ABP – 313278 – 22

(DCC Ref: SHD009/22)

White Heather Industrial Estate, South Circular Road, & 307/307a South Circular Road and 12a St James's Terrace, Dublin 8.

TRANSPORTATION PLANNING DIVISION REPORT

Fig. 47: Excerpt from Dwg. No. 300726-001- 'Preliminary Access Junction Layout'

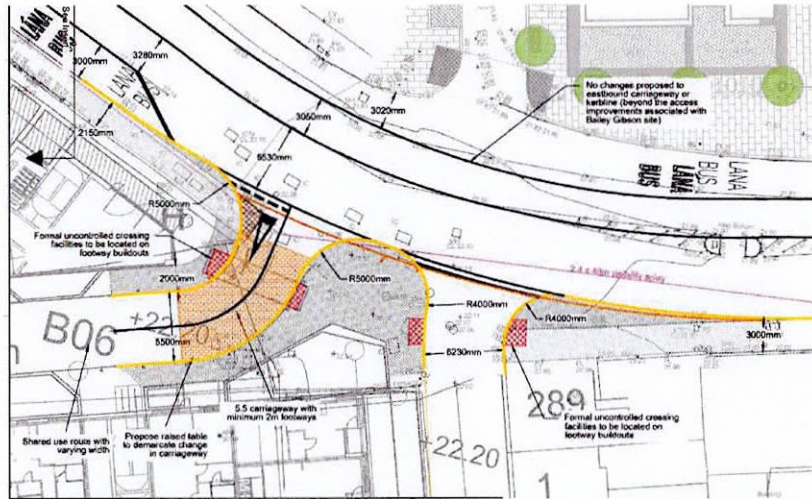
It is proposed to change the existing access to a simple priority of 5.5 m width and 5 m radii. Drawings have been submitted confirming that the proposed junction design allows for the access and egress of servicing and emergency vehicles for both the site and the adjoining Priestfield Cottages. The junction has been designed to DMURS standard. It is noted that the proposed design will also improve the junction layout which is shared with the adjoining Priestfield Cottages and create 2 separate accesses both to Priestfield and the application site. The existing arrangement is of a c.21 m wide vehicular access. The proposal will create 2 no. vehicular access points with buildouts and substantially improved pedestrian facilities

A drawing have been submitted showing that visibility splays can be achieved each way for the access to the proposed development. However, no visibility splay are provided for the amended access into Priestfield Cottages. This matter was raised at opinion stage and has not been addressed. As noted under item 2.1 in Stage 1 RSA (Appendix C of the TTA), the visibility splays along South Circular Road may be obstructed for drivers exiting both access point by vehicles parked along the south side of the road. Measures ensure visibility splays can be

achieved shall also address Item 2.2 of the RSA. In the event of an approval and in agreement with the Area Engineers in DCC, the applicant shall ensure that visibility splays can be achieved for the revised access points to both the application site and Priestfield Cottages.

Fig. 48: Copy of Dwg. No. 300726-010 - 'Access Junction Swept Path Analysis'

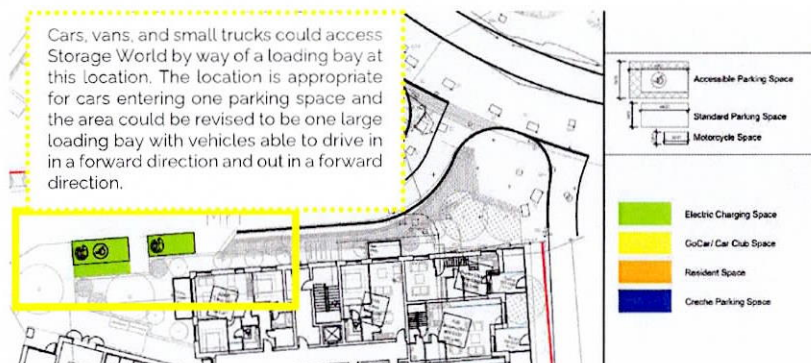
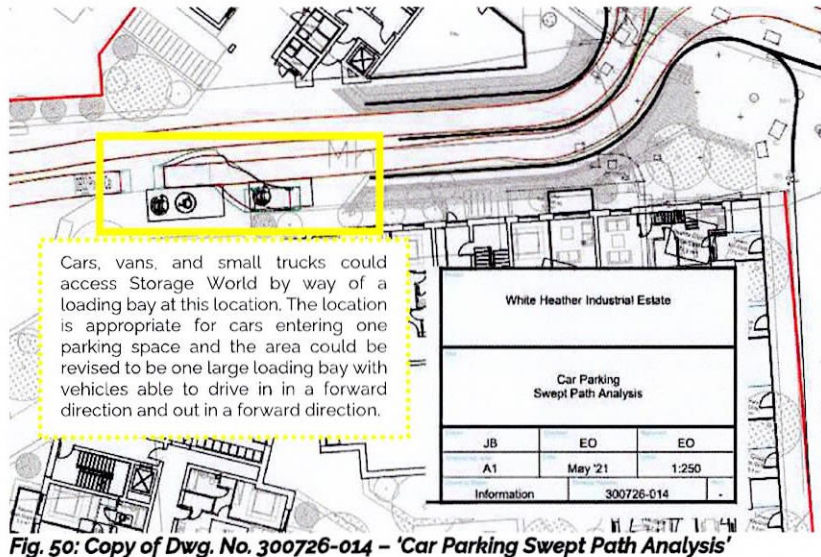
Bin storage areas will be provided internally with bins brought out to the appropriate set down areas by the management company for collection. Access routes for service vehicles have been assessed using Auto Track to ensure a 7.9 m refuse vehicle can access and egress the site

safely. Full analysis drawings are provided in SYSTRA Drawing No. 300726-010 included within Appendix B of the TTA and within the package of plans submitted.
